## **ERYC (and LLFA) responses to ISH4 9<sup>th</sup> April 2025 Action Points.**

### **Action No. 7**

**Converter station access road culvert sizing Paragraphs 37 and 38 of the Outline Drainage Strategy revision 3 [REP2-031] explain watercourses would pass below the proposed permanent access road to the proposed converter station and a suitably sized culvert would need to be provided to maintain existing flows. Would it be useful for the Applicants to commit to an expected minimum design standard? If so, what would this be? (For example, no increased risk of flooding for all storm events up to 1% annual exceedance probability plus an allowance for climate change.)**

Title:
Watercourse Crossings (Main Rivers and ordinary watercourses)

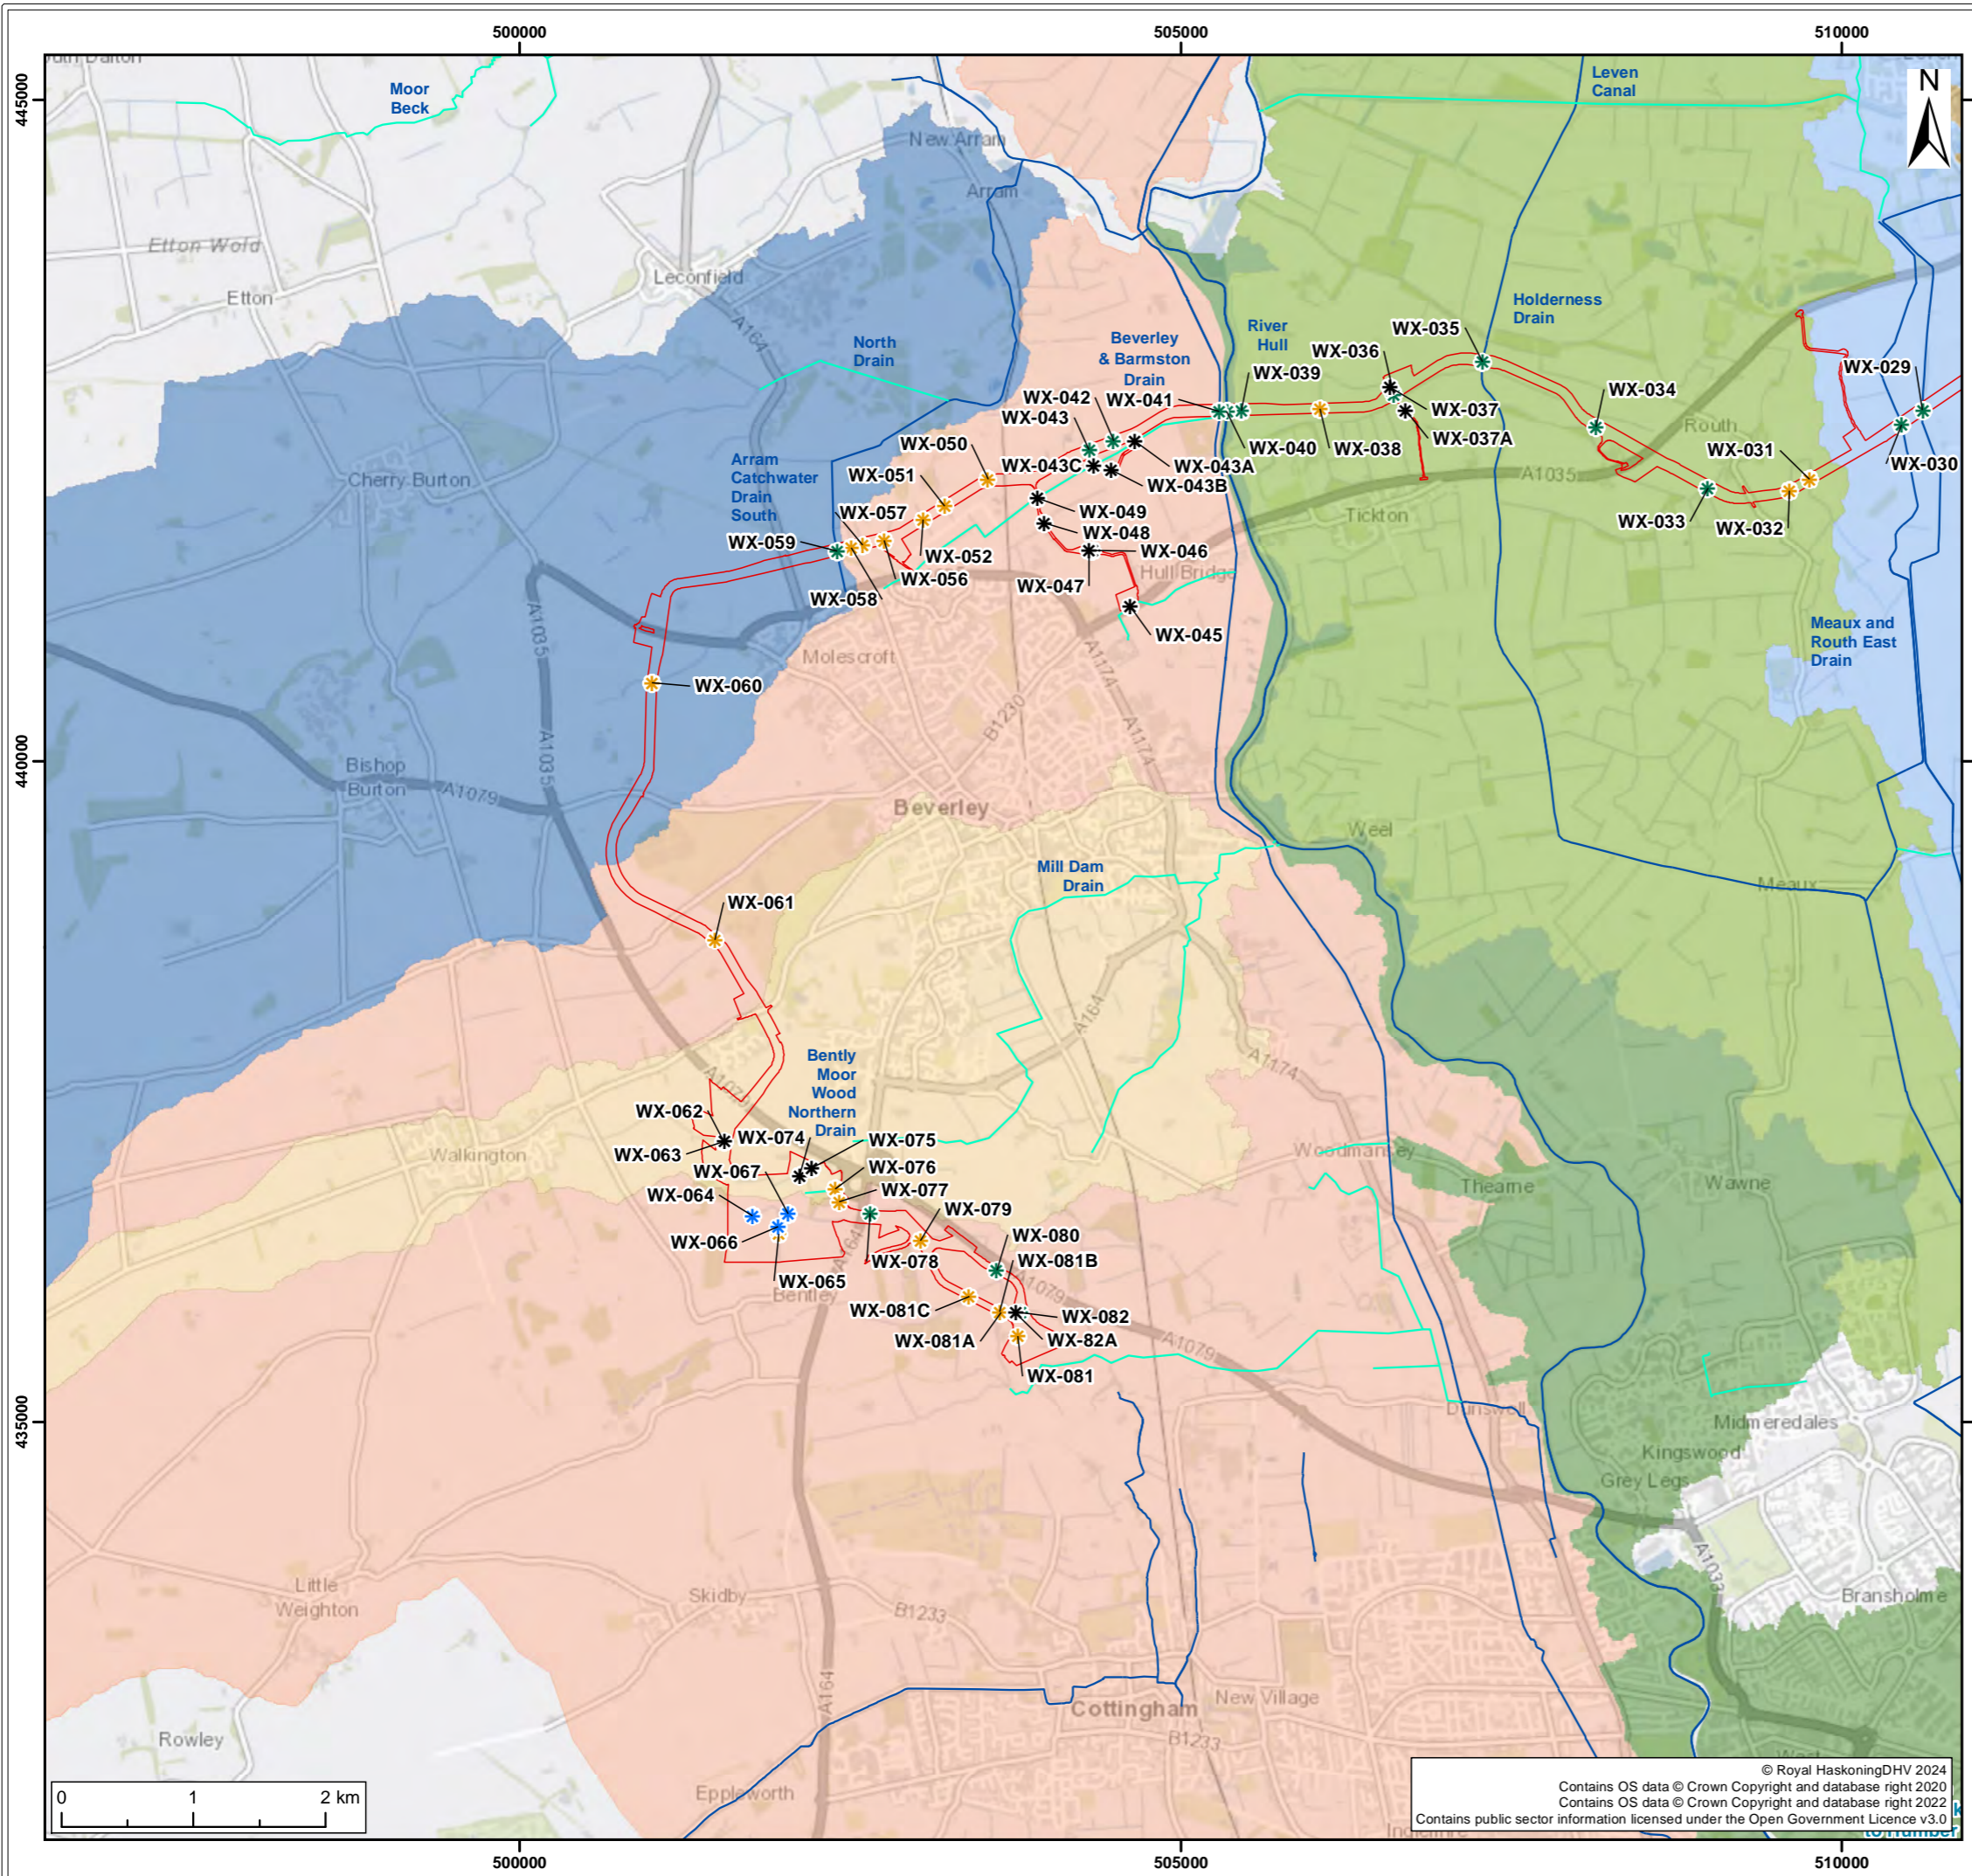
LLFA Response: Temporary watercourse crossings should be assessed with the same scope than that of permanent crossings, taking into account both number of crossings and durations

Response: The main concern would be the watercourses where HDD is not used, and the reinstatements of any watercourses are carried out under supervision. The applicant should demonstrate how reinstatements will be monitored/maintained following the construction phase
